RE: Neyland Court (Ref: 76364/APP/2021/4604)

From: Nesha Burnham
Sent: 30 January 2022 21:12
To: nigel <nigel@hr-architects.co.uk>
Subject: Neyland Court (Ref: 76364/APP/2021/4604)

Please could you clarify what is meant by the annotation 'kerbs realigned' on the proposed site plan? Would this involve any changes to the refuse store adjacent to the existing garage block or to the existing wall dividing the car park from the communal garden?

CLIENT	Anslip UK Ltd		
PROJECT	Proposed Management Office for 11-17 Neyland Court, Pembroke Road, Ruislip, HA4 8NQ		
TITLE	Proposed Block Plan

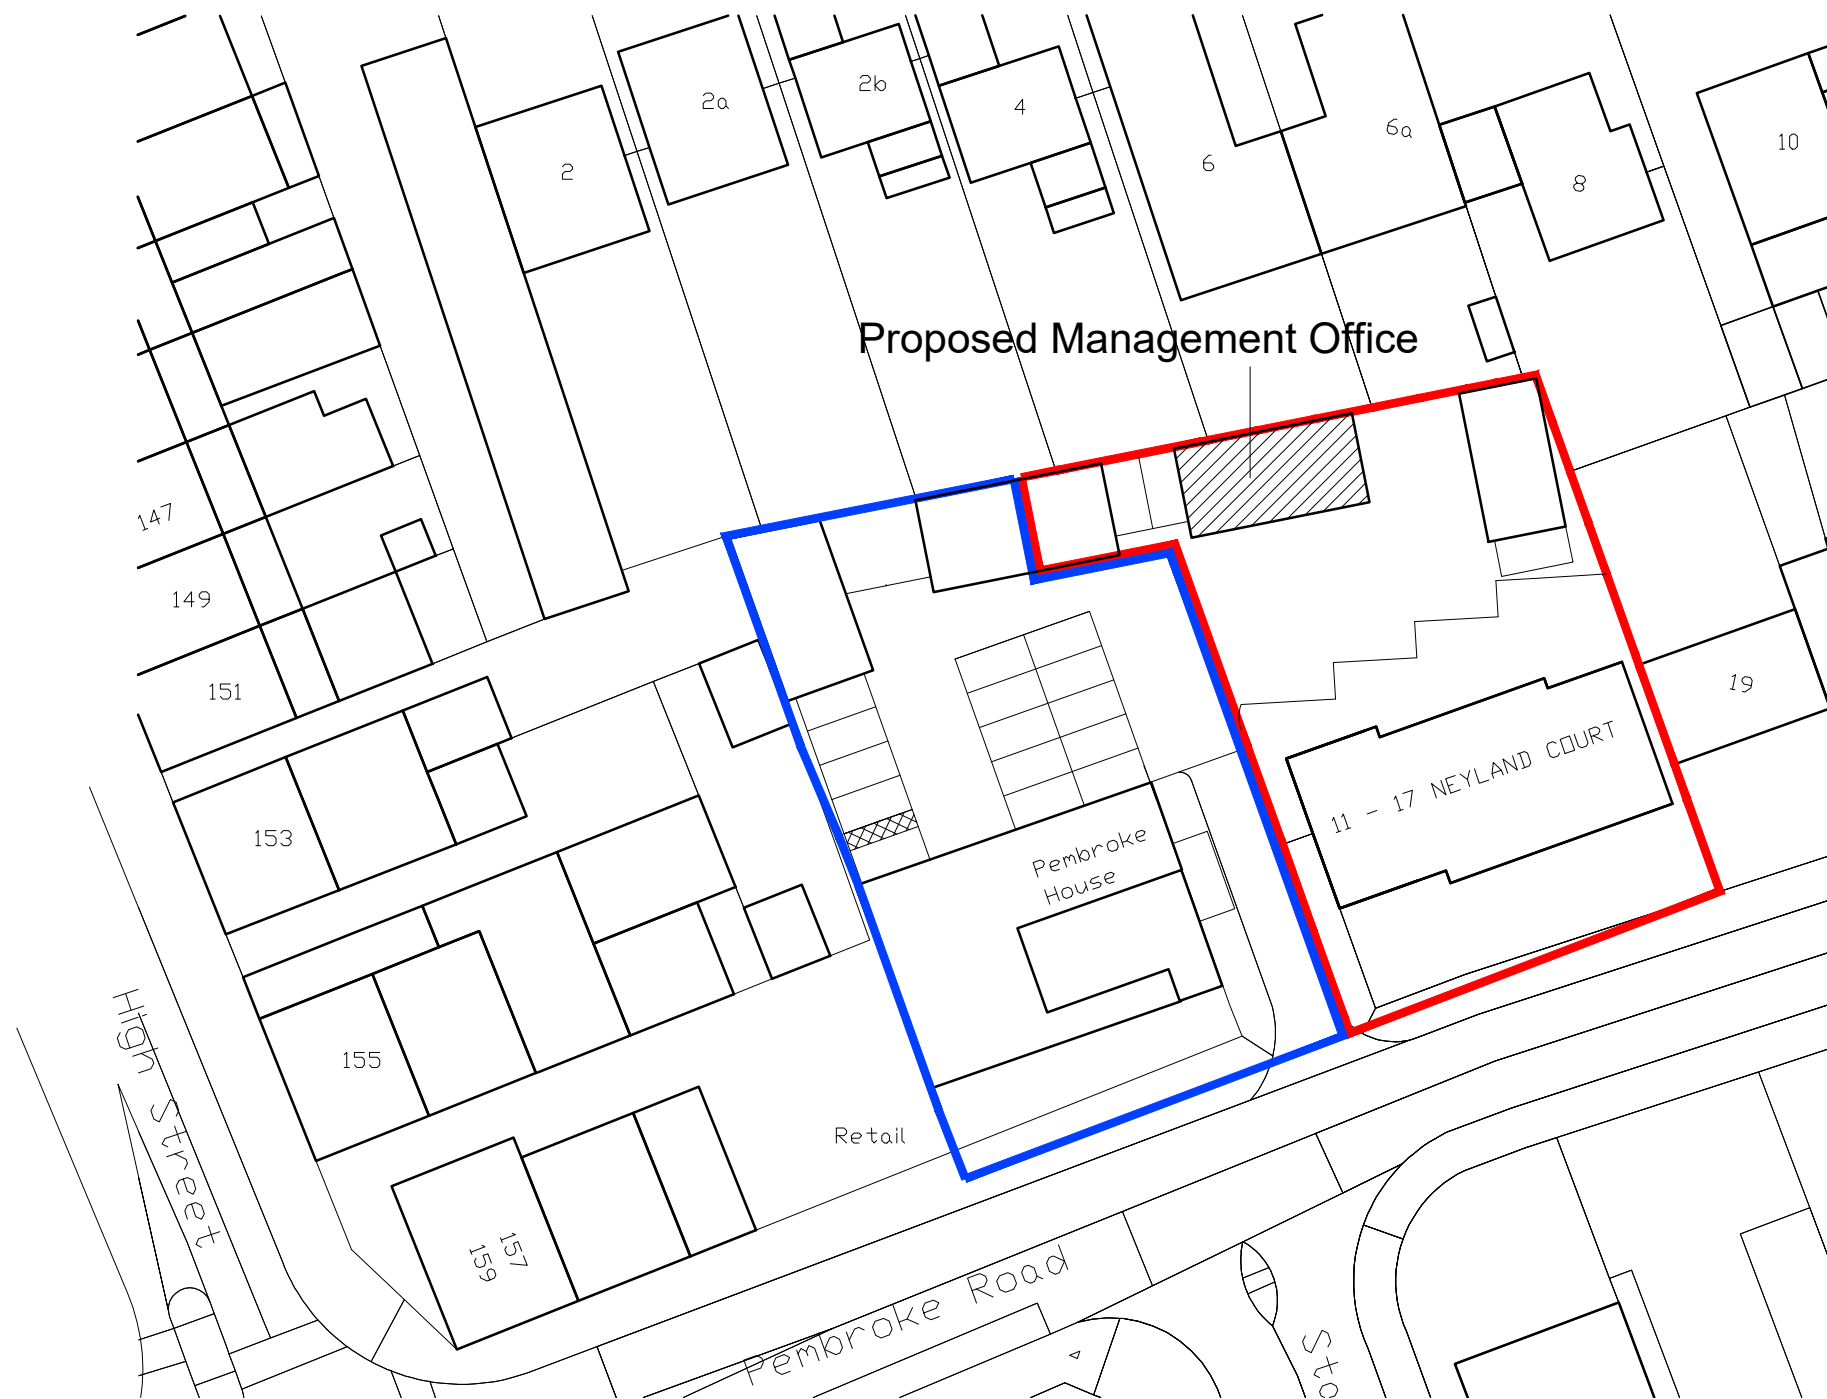
Please could you provide a drawing specifically detailing the exact works that would be involved in the proposed kerb realignment?

Please find attached a slightly revised car parking layout for your consideration.
As you will see these changes actually provide a net gain in the useable amenity area for the existing flats and more area within the car park for refuse storage.
